**Request for Comments – Cricket NSW Centre of Excellence,
Sydney Olympic Park (SSD-10354)**

I refer to your request for comments on SSD-10354 for the development of Wilson Park for the Cricket NSW Centre of Excellence.

20 December 2019

**Tree Management Plan
sheet 1**

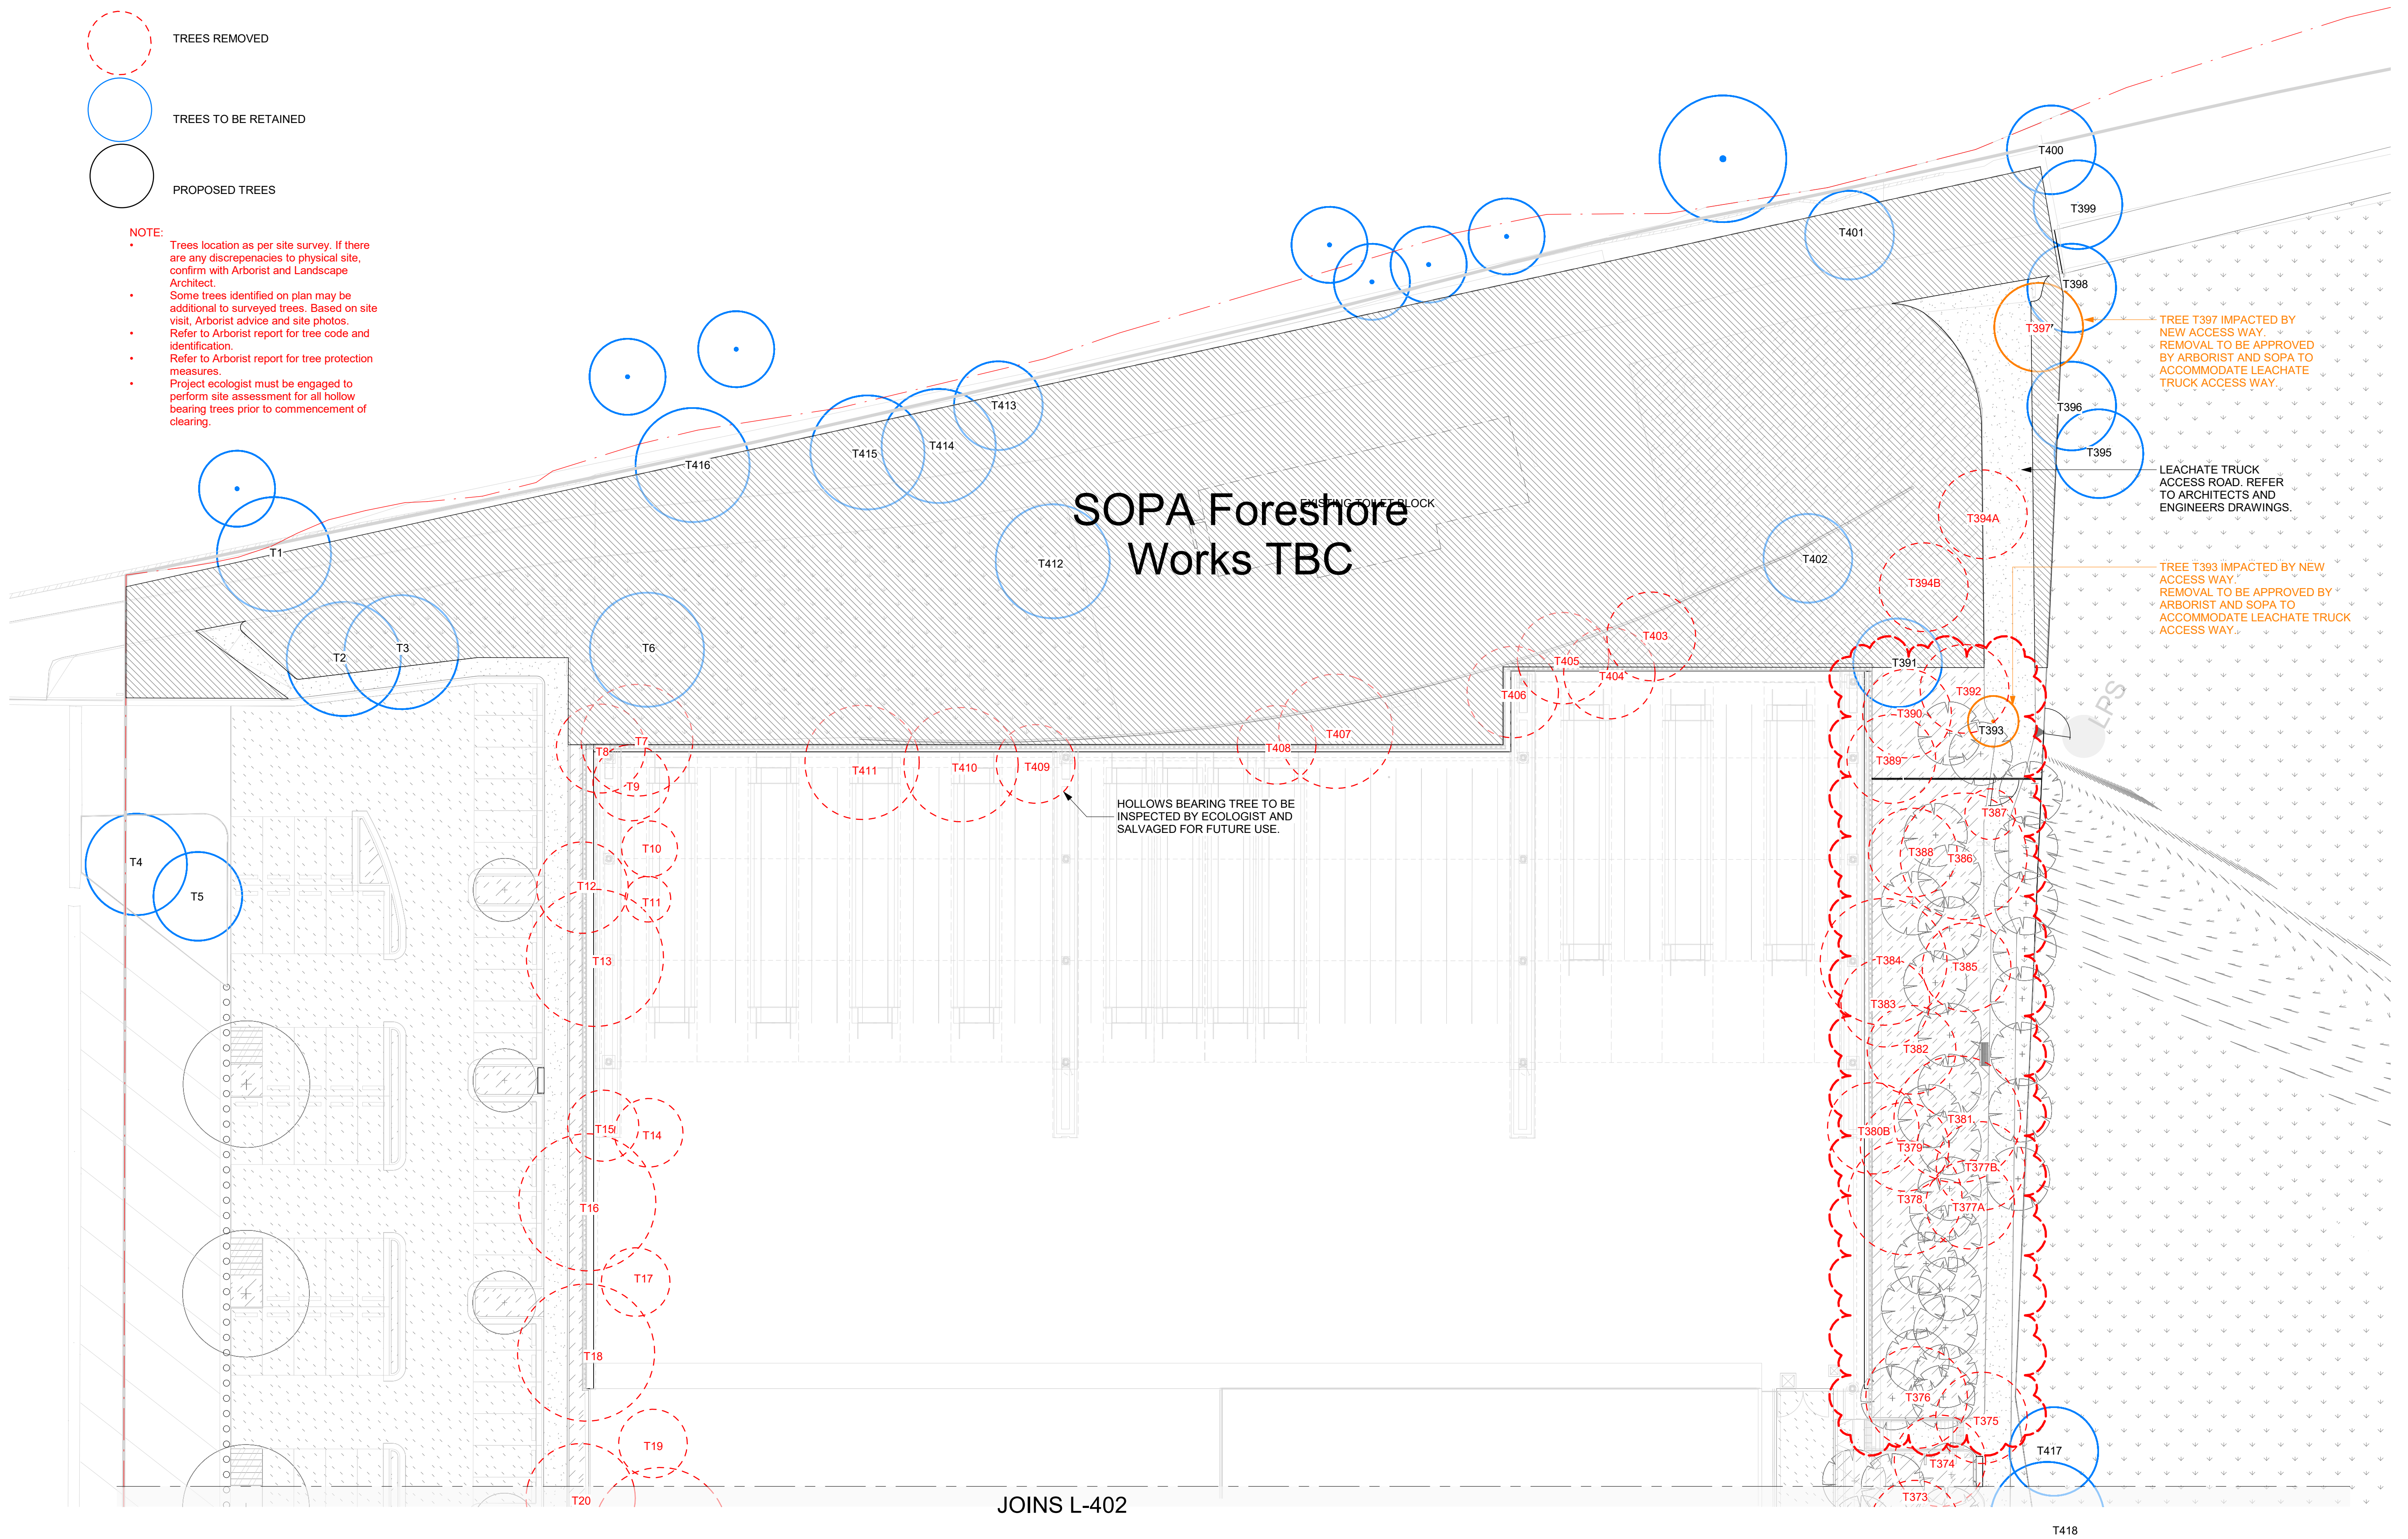
- The EIS identifies that 304 trees will be removed, and 310 replacement trees will be planted. These figures conflict with the Biodiversity Report, which states 108 trees covering 1.3 hectares will be removed. Clarification is then required in relation to the number of replacement trees, particularly as the replacement of 304 mature trees with 310 juvenile specimens, as proposed in the Landscape Plan is inadequate to compensate for the loss of habitat, shade and functional value.
